2190460

## Response to Submissions

### 89 John Whiteway Drive, Gosford – SSD 10362

- LIVING AREAS
- PRIVATE OPEN SPACE -
BALCONY AREAS

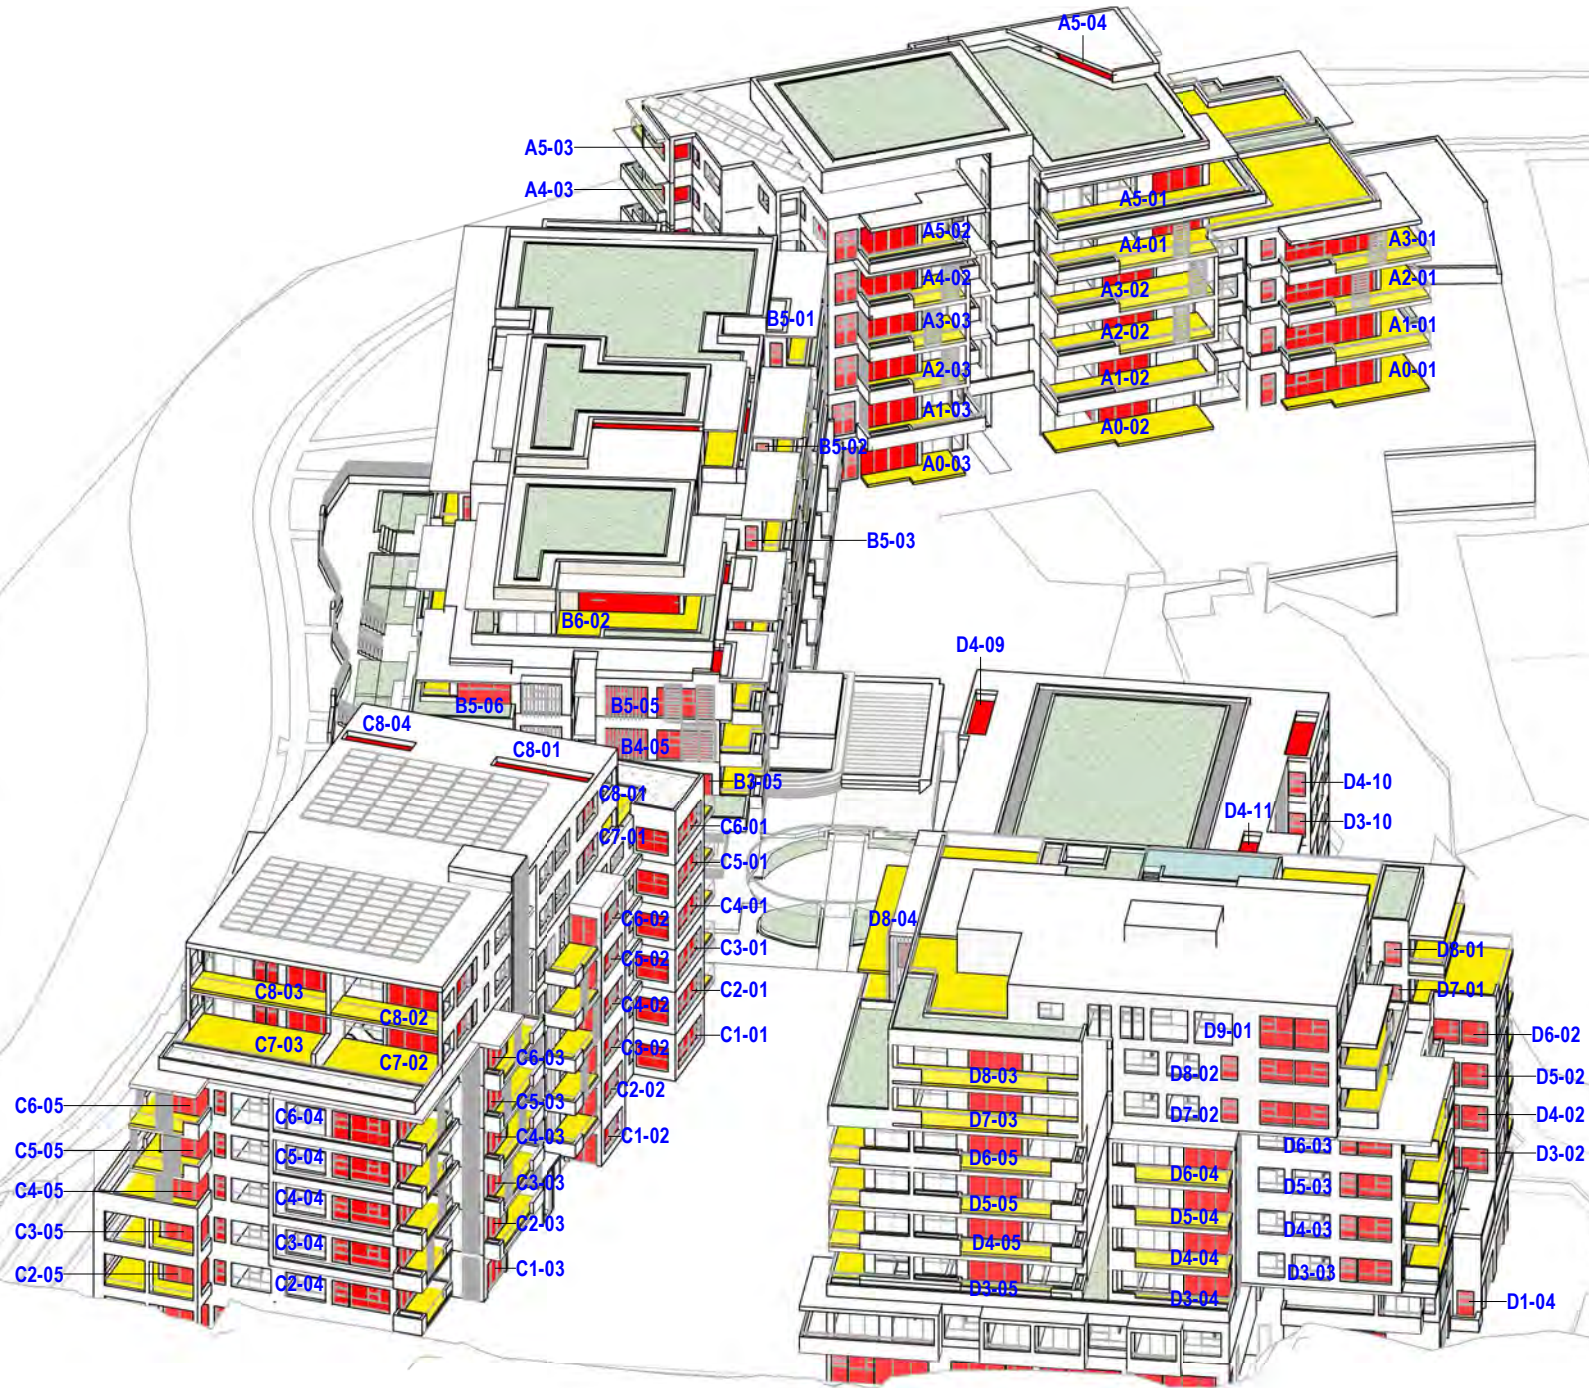
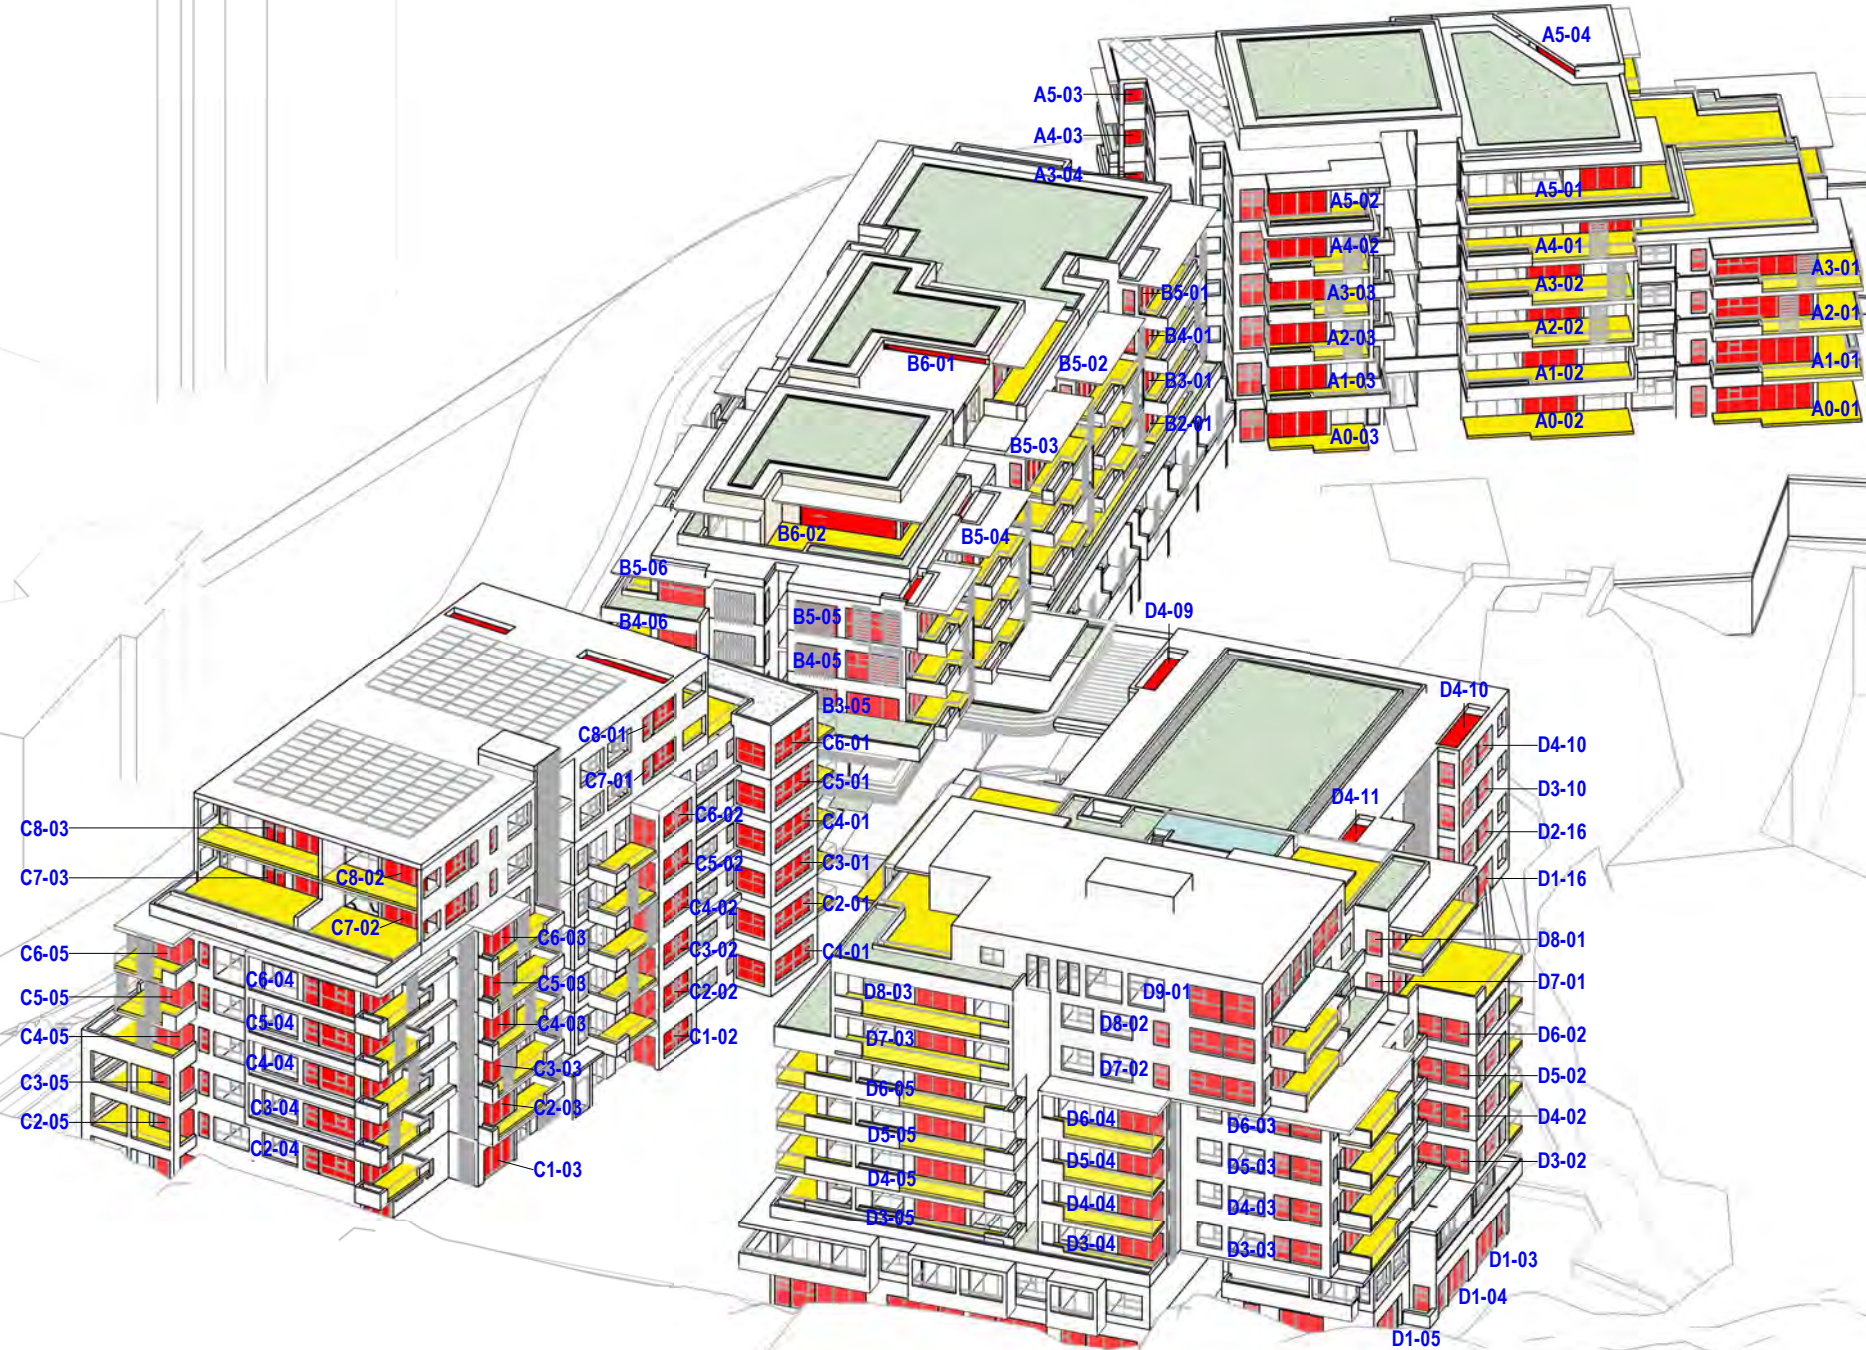
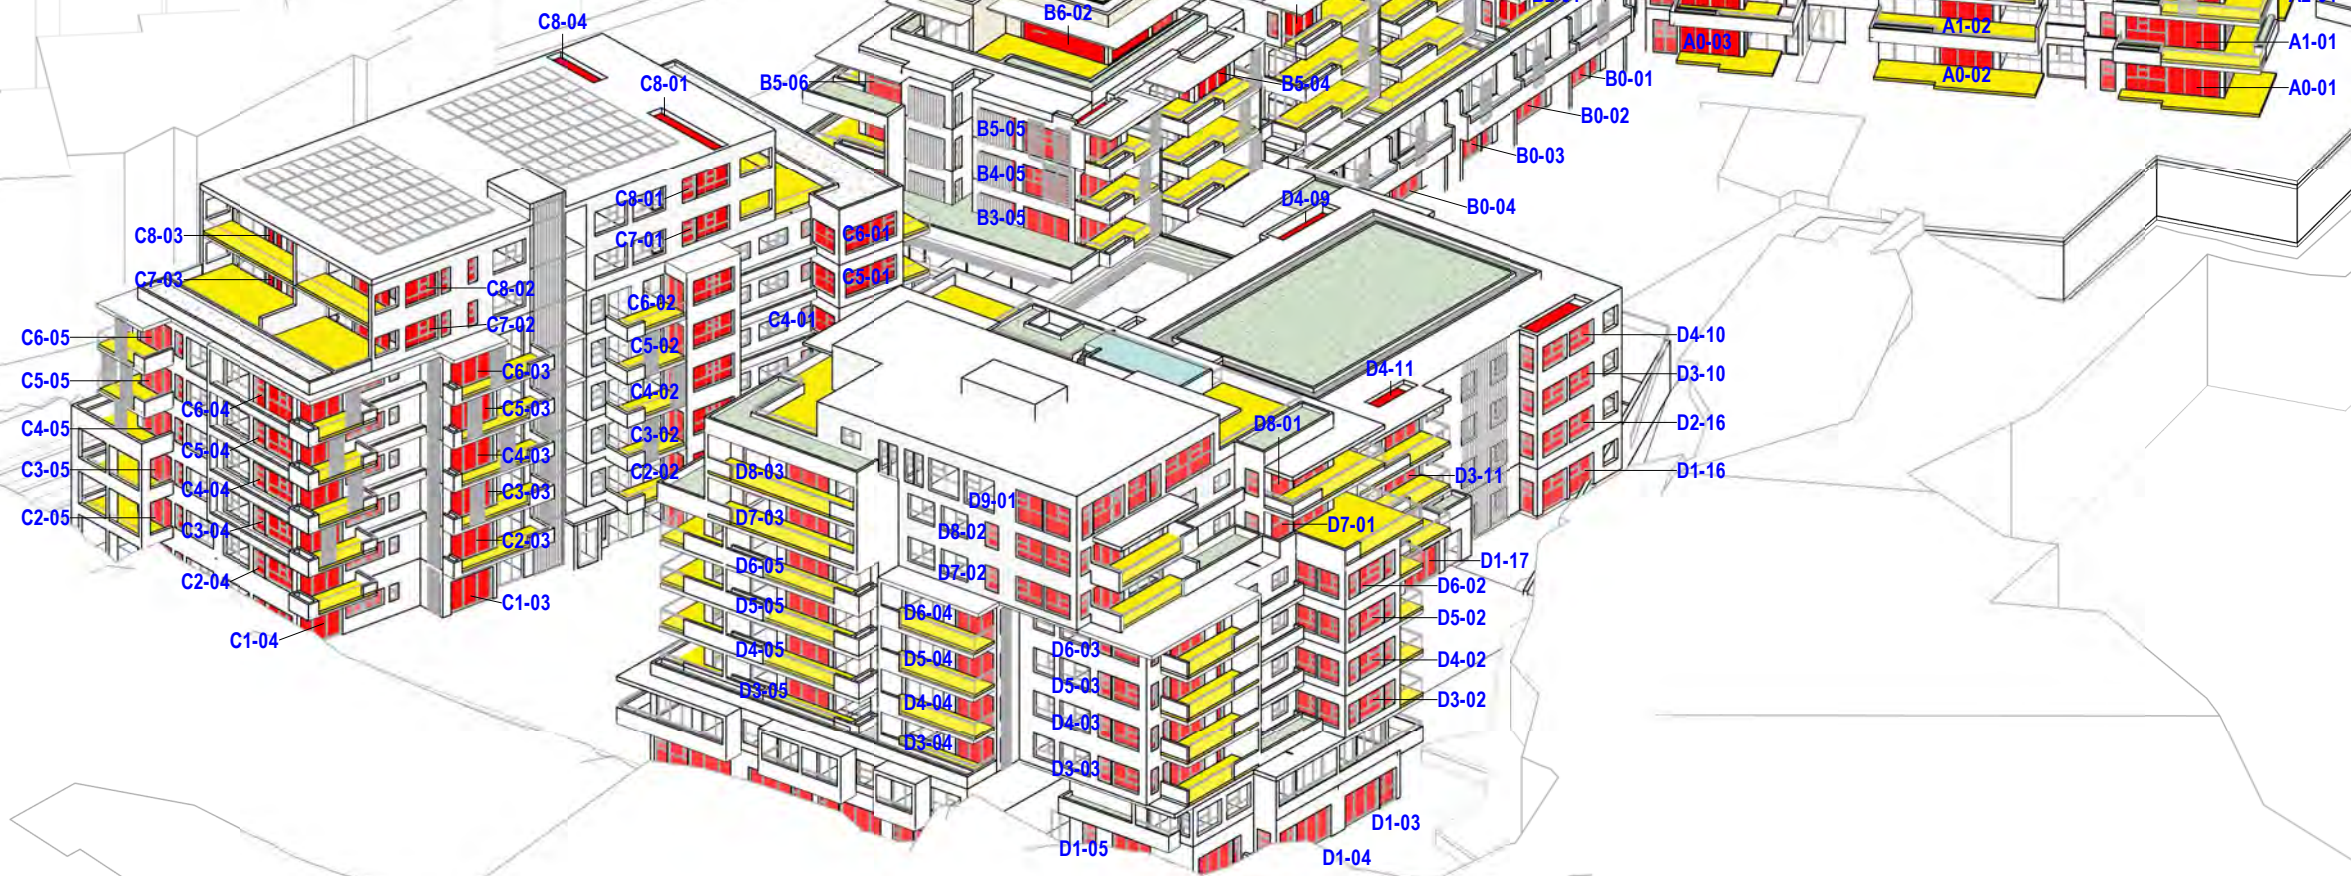
Comment	Comment
<b>Department of Planning, Industry and Environment</b>	
<p><b>Solar and daylight access</b> Please provide amended sun eye diagrams to clearly indicate where the living spaces and balconies are located. This information is required to allow cross reference between the solar access/overshadowing floor plan diagrams, summary schedules and the view from the sun.</p>	<p>New Sun Eye diagrams that are zoomed in with additional notated details are provided.</p>
<p>Please include elevation plans in the overshadowing analysis indicating the location of habitable rooms and private open space.</p>	<p>The Sun Eye Diagrams provide these details.</p>
<p>Please indicate the 40 units which will not receive 3 hours of sunlight but will have water views.</p>	<p>See Architectural Plan DA006.7D- DA006.7F</p>
<p>Please identify the units that receive 3 hours of sunlight to provide a complete understanding of the variation proposed.</p>	<p>See Architectural Plan DA006.7G- DA006.7I</p>
